**WELWYN HATFIELD BOROUGH COUNCIL  
EXECUTIVE DIRECTOR - PLANNING, PUBLIC PROTECTION AND GOVERNANCE**

**DELEGATED APPLICATION**

**Application No:** 6/2020/2587/PN27  
**Location:** Manor Cottage Vineyards Road Northaw Potters Bar EN6 4PQ  
**Proposal:** Prior approval for the construction of an additional storey to facilitate the enlargement of the dwellinghouse to a maximum of approximately 8.986m in height.  
**Officer:** Ms Emily Stainer

**Recommendation:** Prior Approval Required and Refused

Project: Manor Cottage, Vineyards Road, Northaw, EN6 4PQ
 Date Drawn: 15/09/2020
 Drawing Title: Proposed Plans A1
 Scale @ A1: As indicated
 Drawing Number: TDC065/ PL/101
 Rev: A

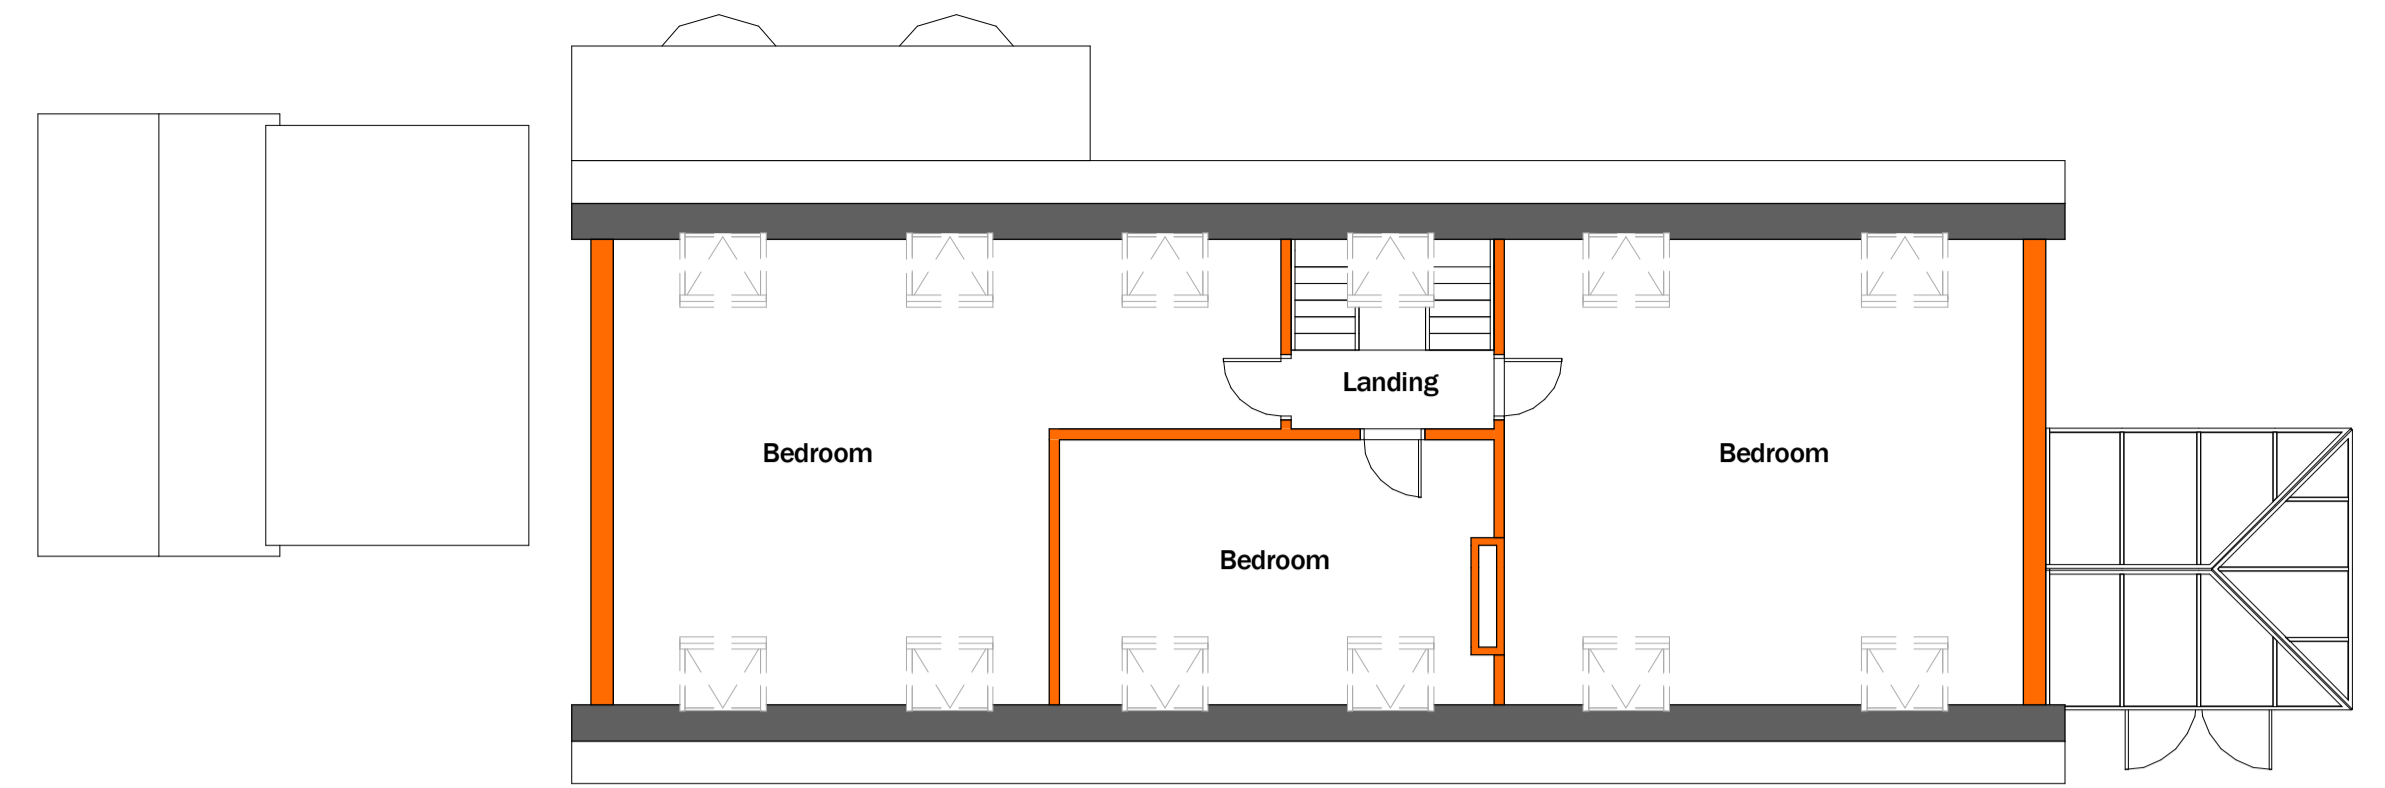
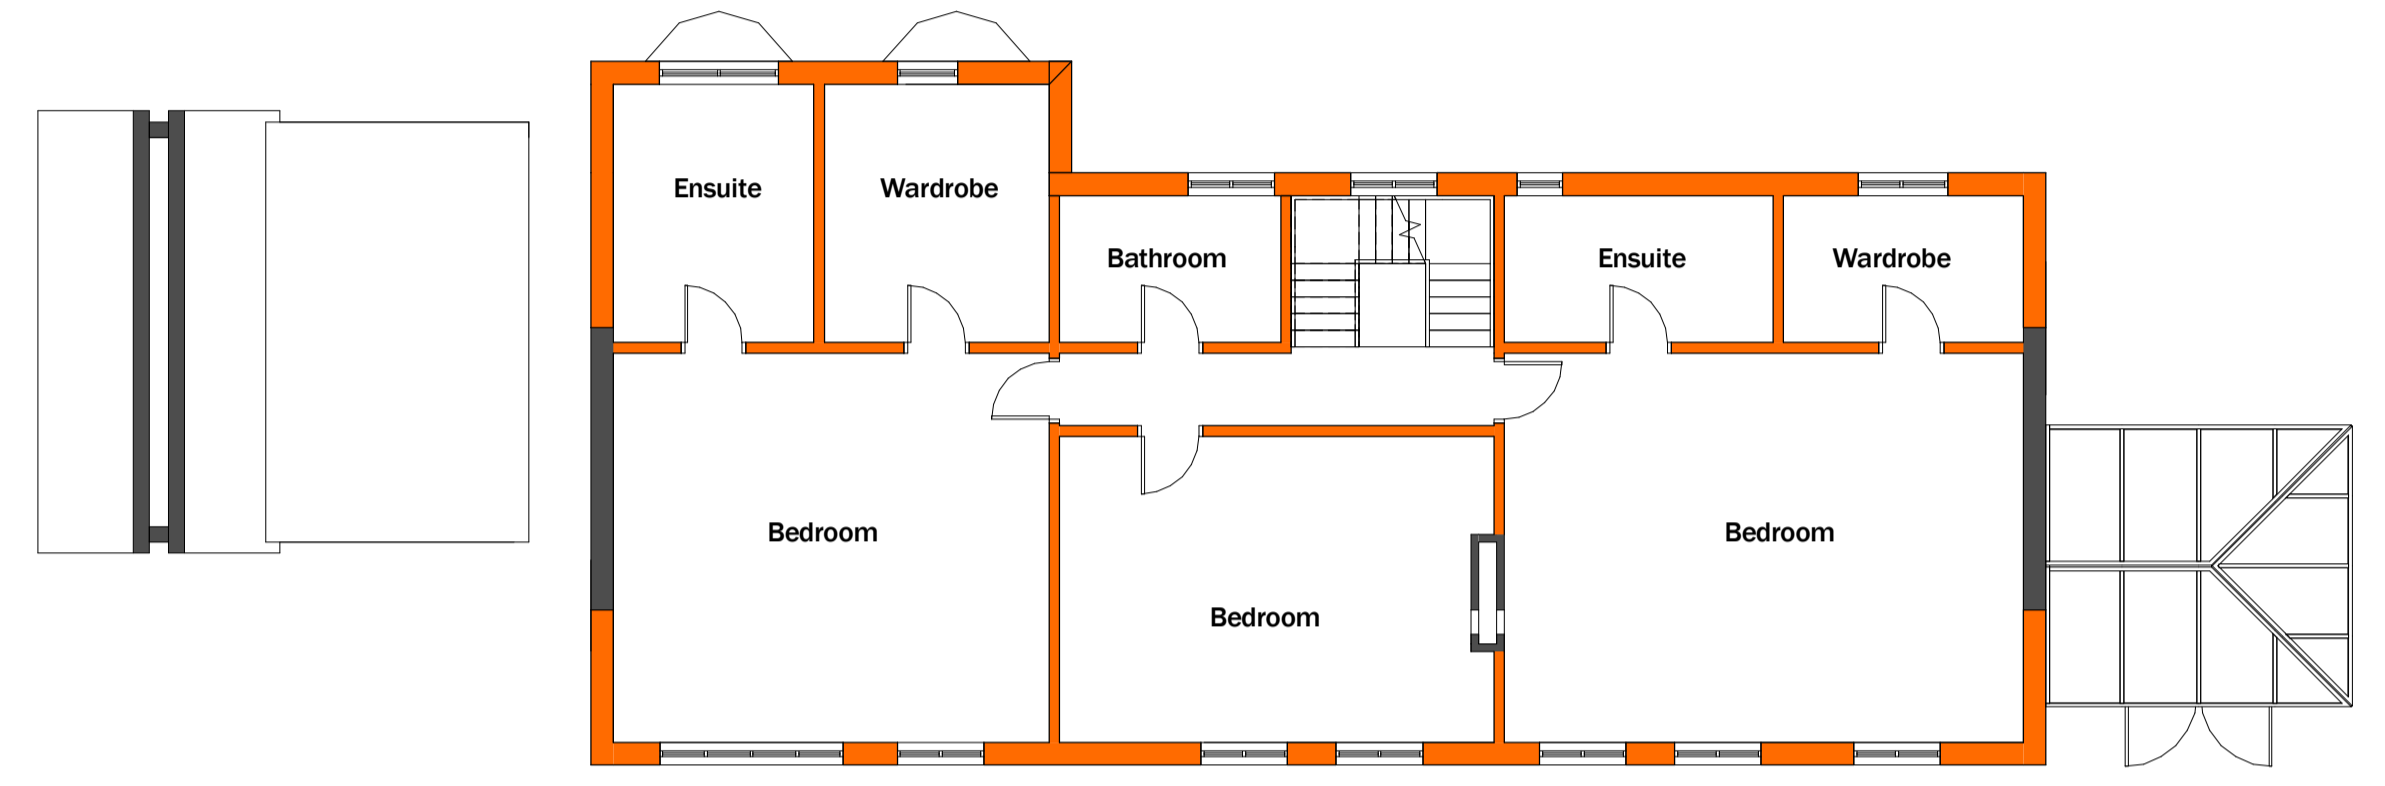
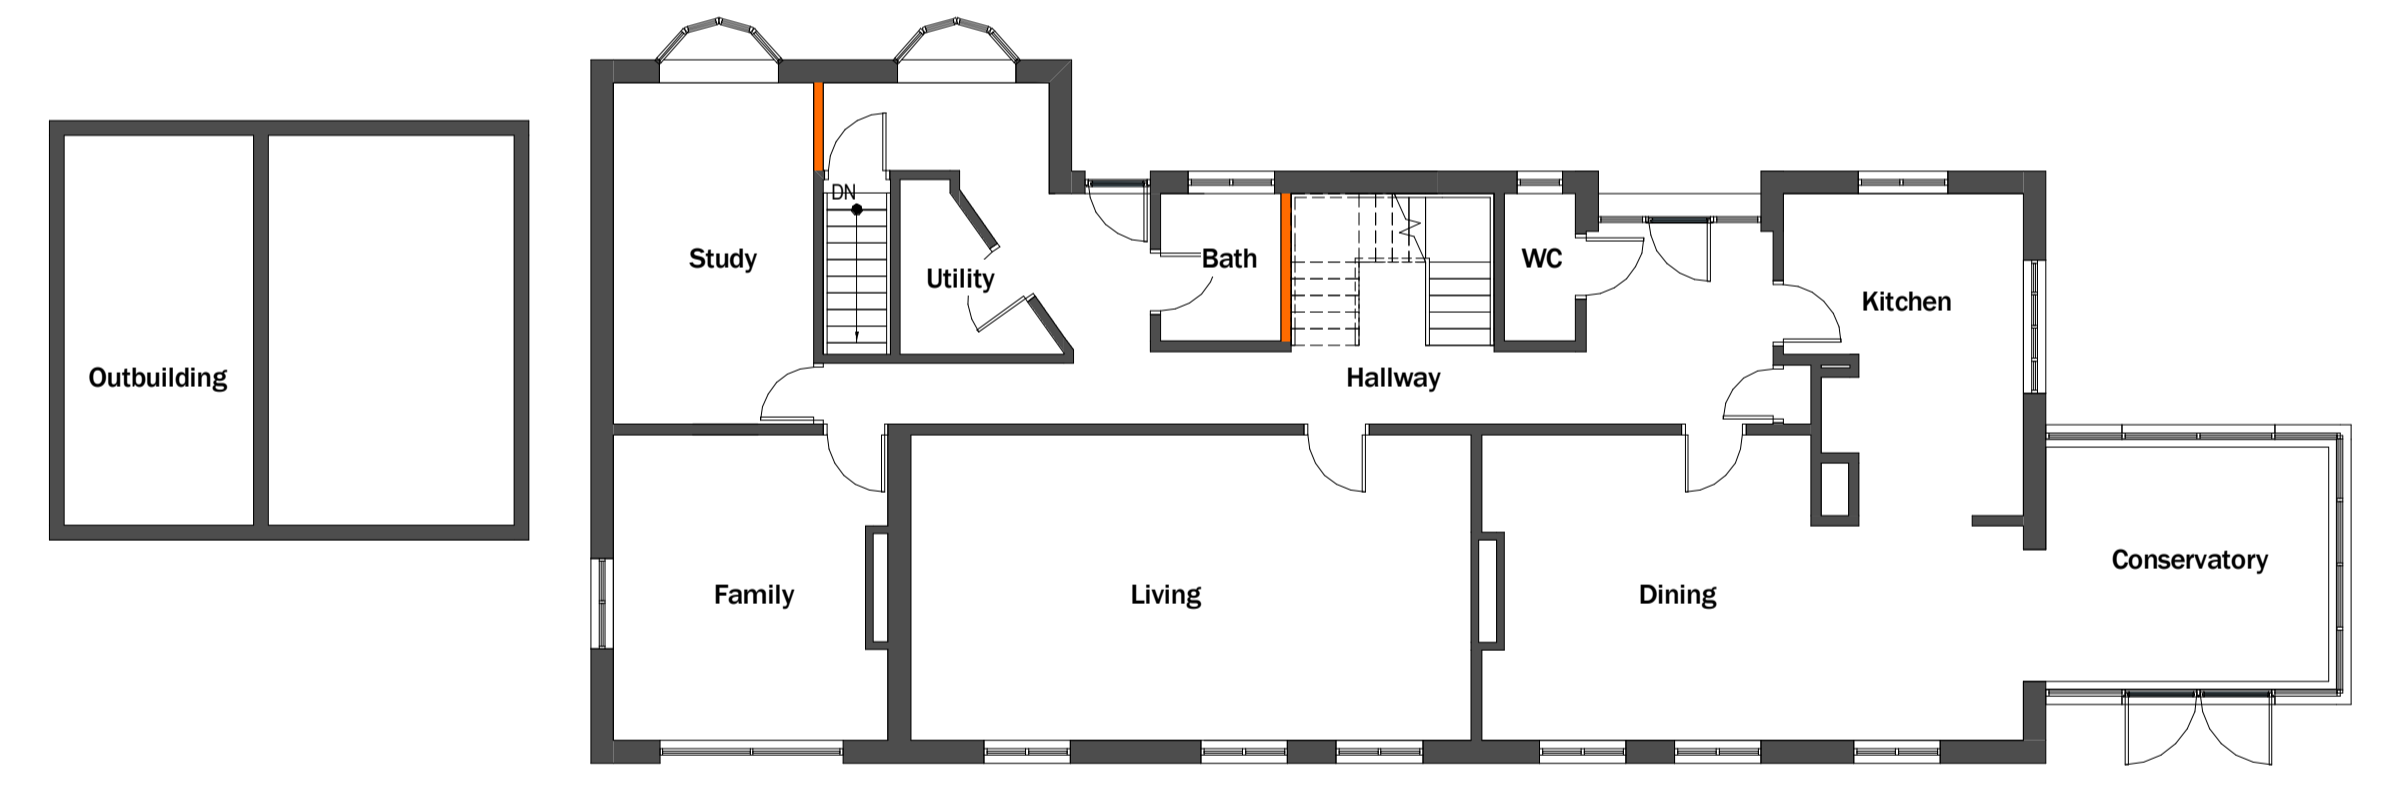
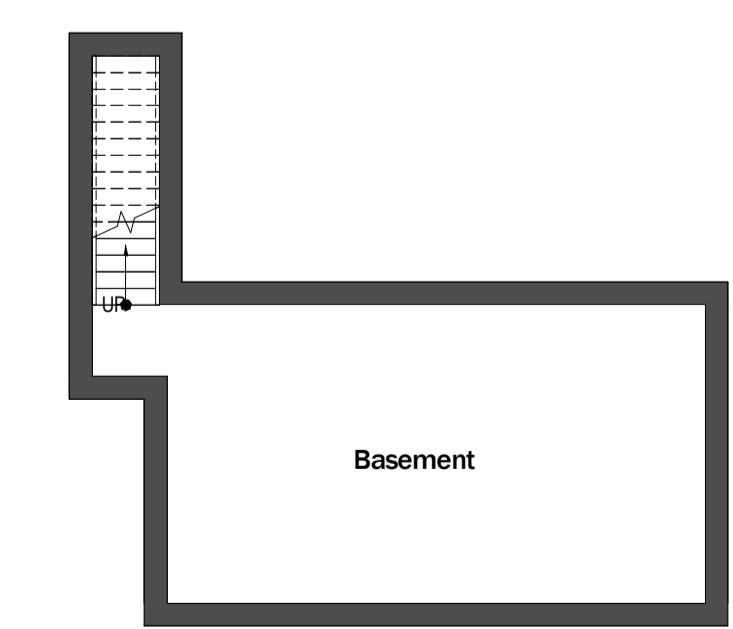
the dwellinghouse is not detached and following the development the height of the highest part of its roof would exceed by more than 3.5 metres— i. in the case of a semi-detached house, the height of the highest part of the roof of the building with which it shares a party wall (or, as the case may be, which has a main wall adjoining its main wall); or ii. in the case of a terrace house, the height of the highest part of the roof of every other building in the row in which it is situated;	<b>N/A - Detached</b>	<b>N</b>
the floor to ceiling height of any additional storey, measured internally, would exceed the lower of— i. 3 metres; or ii. the floor to ceiling height, measured internally, of any storey of the principal part of the existing dwellinghouse;	<b>N – 2.3m</b>	<b>N</b>
any additional storey is constructed other than on the principal part of the dwellinghouse;	<b><u>Y – see discussion</u></b>	<b>N</b>

<b>Conditions that the development must apply for Prior Approval for:</b>		
The impact on the amenity of any adjoining premises including overlooking, privacy and the loss of light;	<b>See below</b>	
the external appearance of the dwellinghouse, including the design and architectural features of—  (aa)the principal elevation of the dwellinghouse, and  (bb)any side elevation of the dwellinghouse that fronts a highway;	<b>See below</b>	
Air traffic and defence asset impacts of the development	<b>See below</b>	
Whether because of the siting of the building, the development will impact on a protected view identified in the Directions Relating to protected views dated 15 March 2012 (3) issued by the SofS	<b>See below</b>	
<b><u>Discussion</u></b>		
<p>Paragraph AA.1 (i) states that development is not permitted by Class AA if any additional storey is constructed other than on the principal part of the dwellinghouse. Paragraph AA.4 (1) additionally clarifies that for the purposes of Class AA, the “principal part” in relation to a dwellinghouse means the main part of the dwellinghouse excluding any front, side or rear extension of a lower height, whether this forms part of the original dwellinghouse or is a subsequent addition.</p> <p>The property currently benefits from a single storey front extension with a flat roof which has a lower height than the ridge of the existing dwelling. The proposed new storey would extend above the existing single storey flat roofed projection to create a two storey element, therefore it is considered an additional storey is constructed other than on the principal part of the dwellinghouse, in conflict with the above criteria.</p>

<b>Discussion where matters require prior approval</b>		
Impact on Amenity	<p>In accordance with section AA.2 (3) (a) (i) of Schedule 2, Part 1, Class AA of The Town and Country (General Permitted Development) Order 2015 (as amended), the local planning authority shall consider the impact on the amenity of any adjoining premises. No neighbour comments have been received.</p> <p>A site visit was made by the case officer in October 2020, but only from public vantage points due to the restrictions in place as a result of the Coronavirus pandemic (COVID-19). A suitable level of information has been acquired in which to make a full and thorough assessment by use of the case officer’s photographs taken from the street scene, additional photographs provided by the applicant and aerial imagery from 2020 on the council’s mapping system. The specific merits of this case means that a full and complete assessment can be made in respect of this particular application.</p> <p>The application property is situated a sufficient distance away from surrounding properties to prevent a substantial impact occurring any impact with regard to an overbearing impact or a loss of light.</p> <p>In terms of privacy, the front windows within the new storey of the existing dwelling would afford views towards the north of the site and towards the residential garden of Nyn Manor Cottage.</p>

<p>Nonetheless, the rooms the windows would serve consist of three bathrooms and two wardrobes. It is therefore unlikely that extended periods of time would be spent in these rooms compared to the main habitable rooms at the property. Rooflights would also be installed in the roof space of the resultant second floor which would be modest in scale and serve bedrooms and a landing area. All of the proposed windows/rooflights on the front of the proposed dwelling are labelled as being obscure glazed on the submitted plans, therefore, the resulting relationship would be unlikely to significantly impact upon the privacy of the occupiers of Nyn Manor Cottage. Subsequently the resulting relationship would not result in an undue loss of privacy.</p>
<p>External Appearance</p>	<p>In accordance with section AA.2 (3) (a) (ii) of Schedule 2, Part 1, Class AA of The Town and Country (General Permitted Development) Order 2015 (as amended), the local planning authority shall consider the external appearance of the dwellinghouse, including the design and architectural features of the following:</p> <p>(aa )the principal elevation of the dwellinghouse, and (bb) any side elevation of the dwellinghouse that fronts a highway.</p> <p>The existing property is finished with a pitched, gable-end style roof and benefits from single storey elements including a front extension with a flat roof and a conservatory to the side. These elements appear as subordinate additions to the main dwelling.</p> <p>The proposed additional storey would be visible from public vantage points as well as from neighbouring dwellings and their gardens. The proposal indicates a pitched gable-end roof above the main dwelling with a two storey flat roofed projection at the front of the property. Whilst the roof design of the majority of the resultant dwelling would be in keeping with the existing dwelling, the proposed front facing two storey projection, by virtue of its flat roof form, would fail to complement and reflect the design and character of the principal part of the host dwelling and would appear as a discordant addition which would contrast with the pitched roof design of the principal dwelling to its detriment.</p> <p>It is acknowledged that the applicant has attempted to replicate the existing pattern of fenestration on the additional storey and resulting roof slope via the addition of numerous windows and rooflights on both the front and rear elevation of the dwelling. Nonetheless, the proliferation of windows and rooflights are considered to be excessive which result in a cluttered and fussy appearance.</p> <p>The comments above demonstrate that the proposed development would fail to take the opportunities available for enhancing or improving the character and quality of the existing dwelling and the surrounding area. Consequently the proposed dwelling would represent a poor standard of design which would be detrimental to the character and appearance of the application site.</p>

1. The additional storey is constructed above a part of the property which is not the principal part of the dwellinghouse. The proposed development therefore conflicts with Paragraph AA.1 (i) of Class AA, Part 1 of Schedule 2 of the Town and Country Planning (General Permitted Development) Order 2015 (as amended).

1 Proposed Front Elevation
1:100

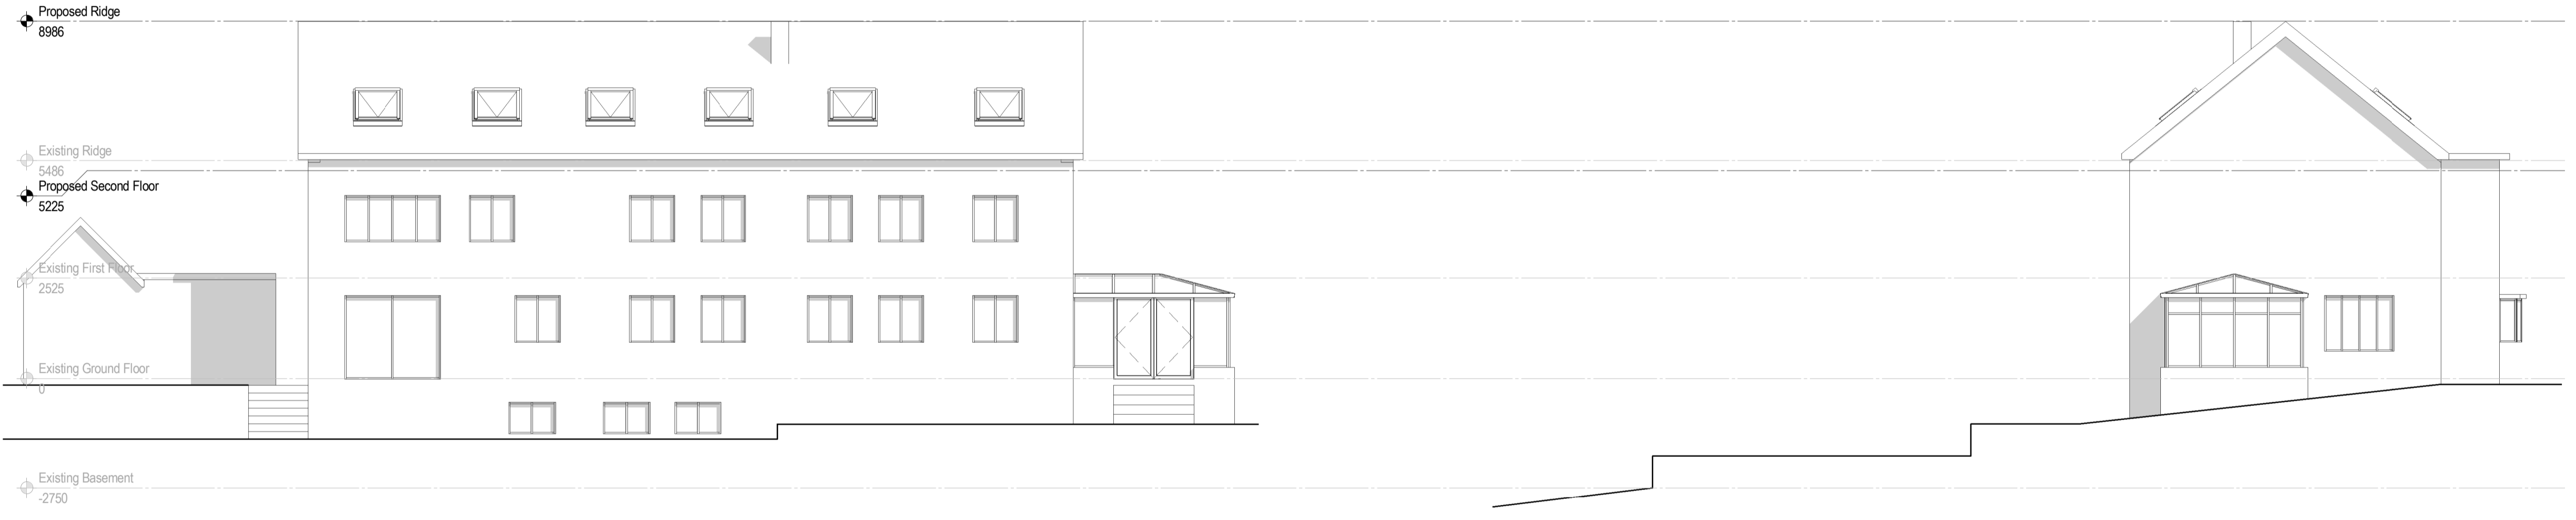
2. The proposed two storey front projection, by virtue of its flat roof design, would fail to complement and reflect the design and character of the principal part of the host dwelling and would appear as a discordant addition which would contrast with the pitched roof design of the principal dwelling to its detriment. Furthermore, the proliferation of windows and rooflights at the property would be excessive and result in a cluttered and fussy appearance. Consequently, the proposed dwelling would represent a poor standard of design which would be detrimental to the character and appearance of the application site.
